Our Ref: BR/281/19/HH
Your Ref:

Town & Country Planning Act 1990 (as amended)
Town & Country Planning (Development Management Procedure) (England) Order 2015
Application for Planning Permission for Works or Extension to a Dwelling

Development Conversion and extension of garage and alterations to carport
Location 6 Rochester Way Aldwick

title Location and Block Plans

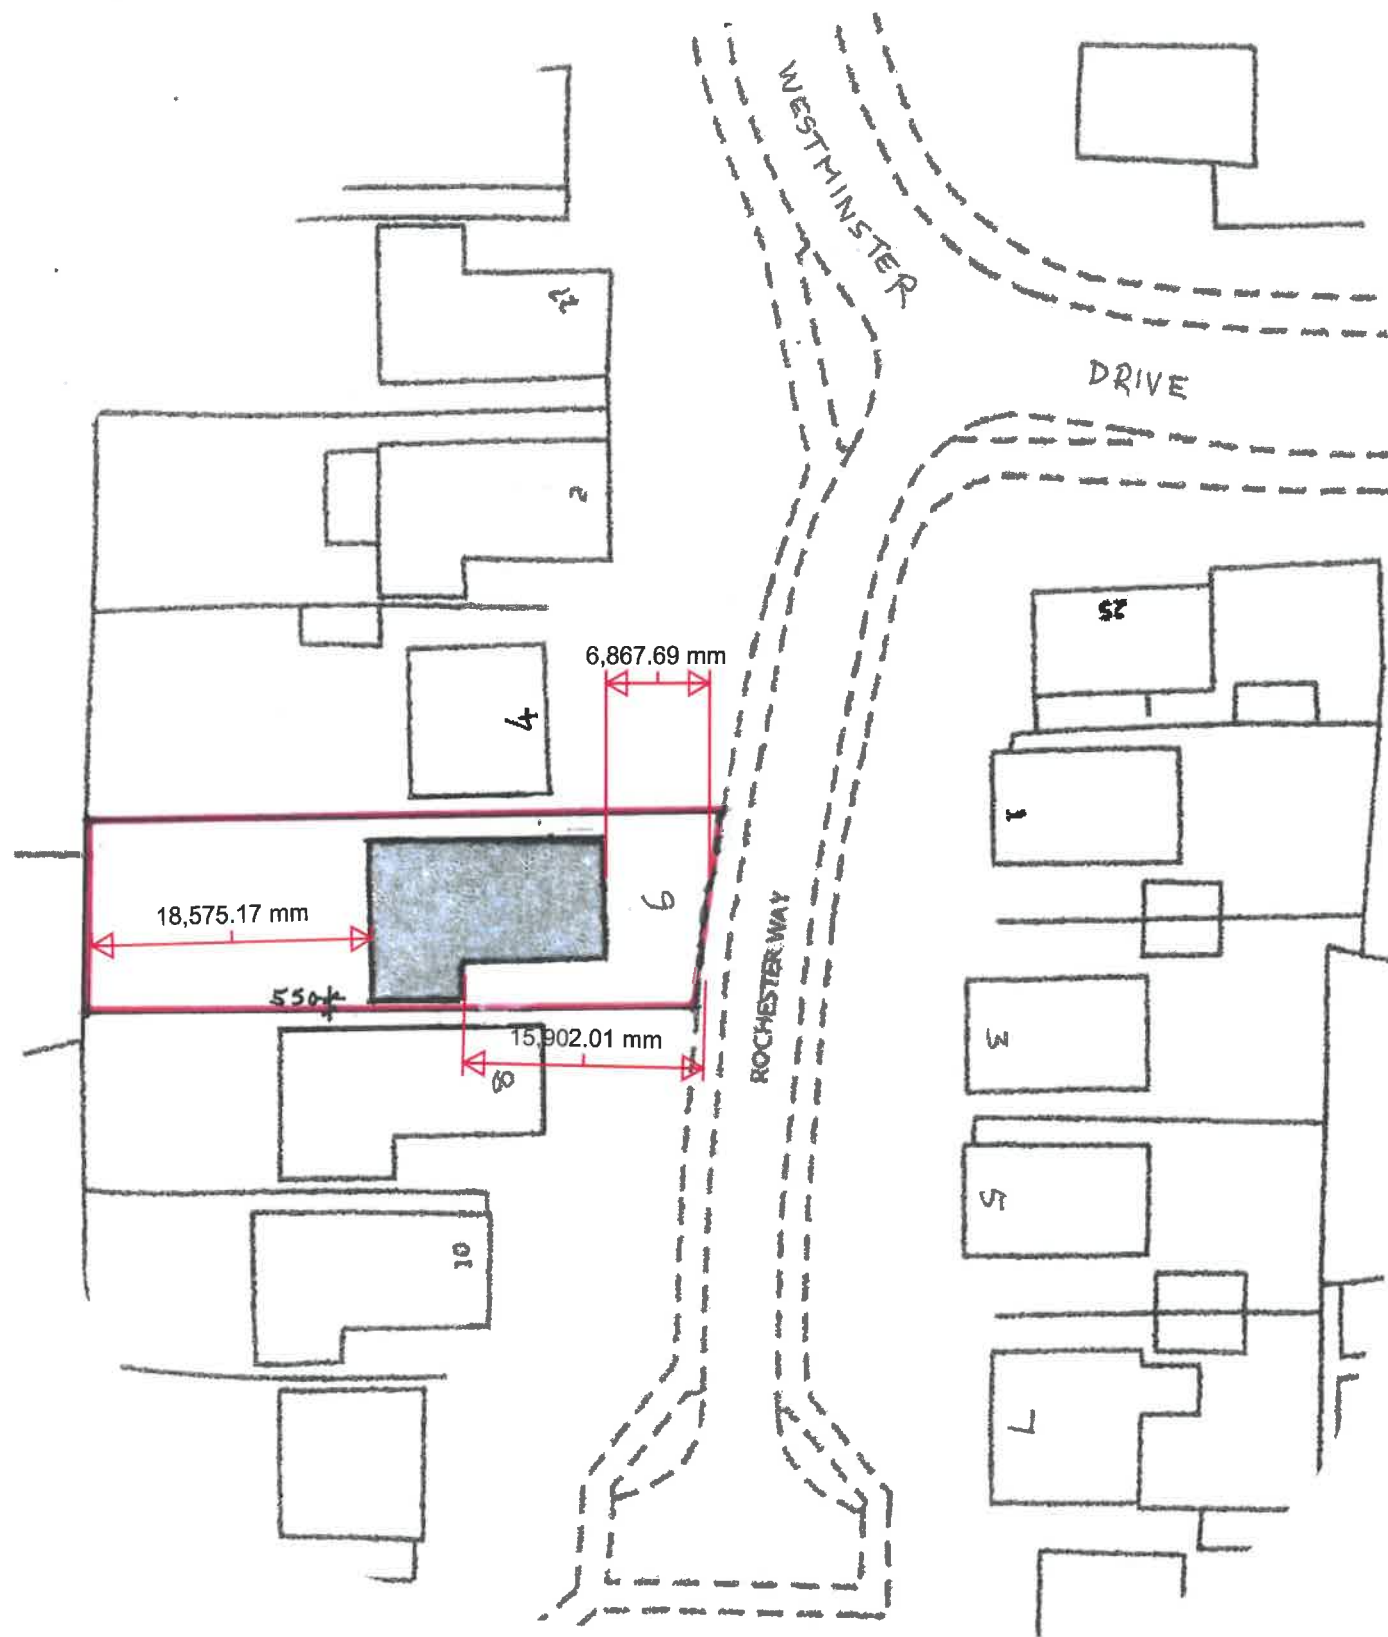
Location Plan

The site to which the application relates must be outlined in red on the location plan.

Block Plan

You are required to annotate the dimensions from the proposed extension to the site boundaries.

computer reference Frampton.1003	project Proposed Alterations to House at 6 Rochester Way, Bognor Regis West Sussex PO21 3RD for Roz Frampton	scale 1:100	title Elevations and Sections as Existing	job no. RBA.028 /	drwg no. 1003	rev A
drawn by JTR		date AUG'19

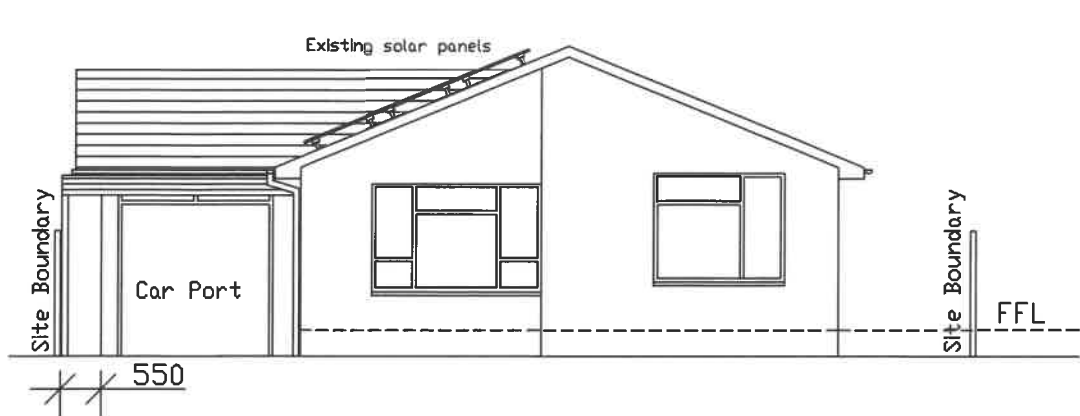
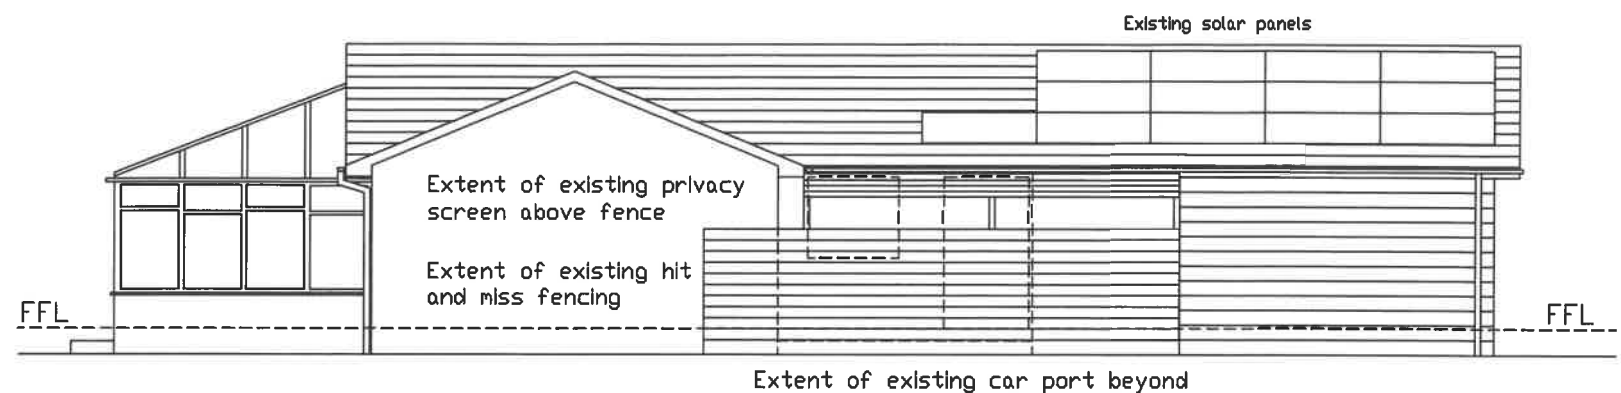
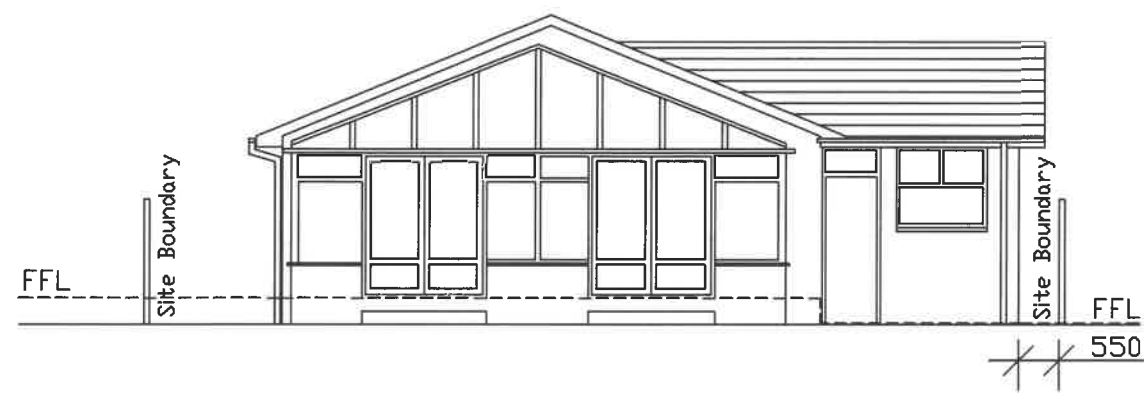
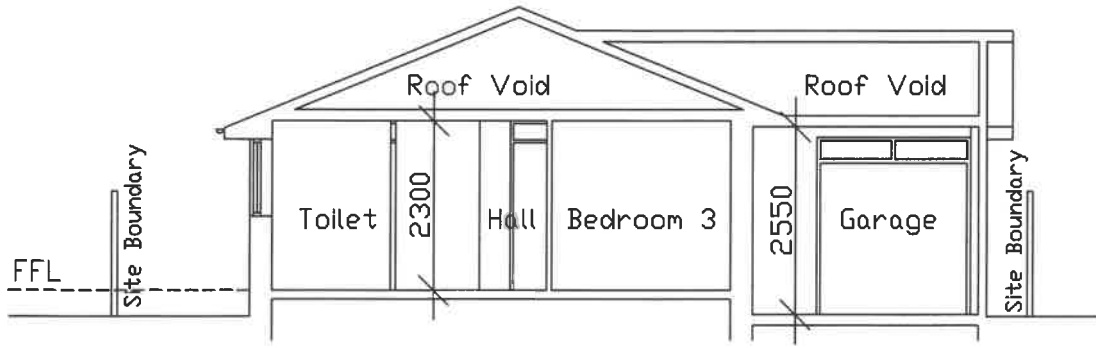
Elevations

Please show the car port on the existing and proposed elevations,
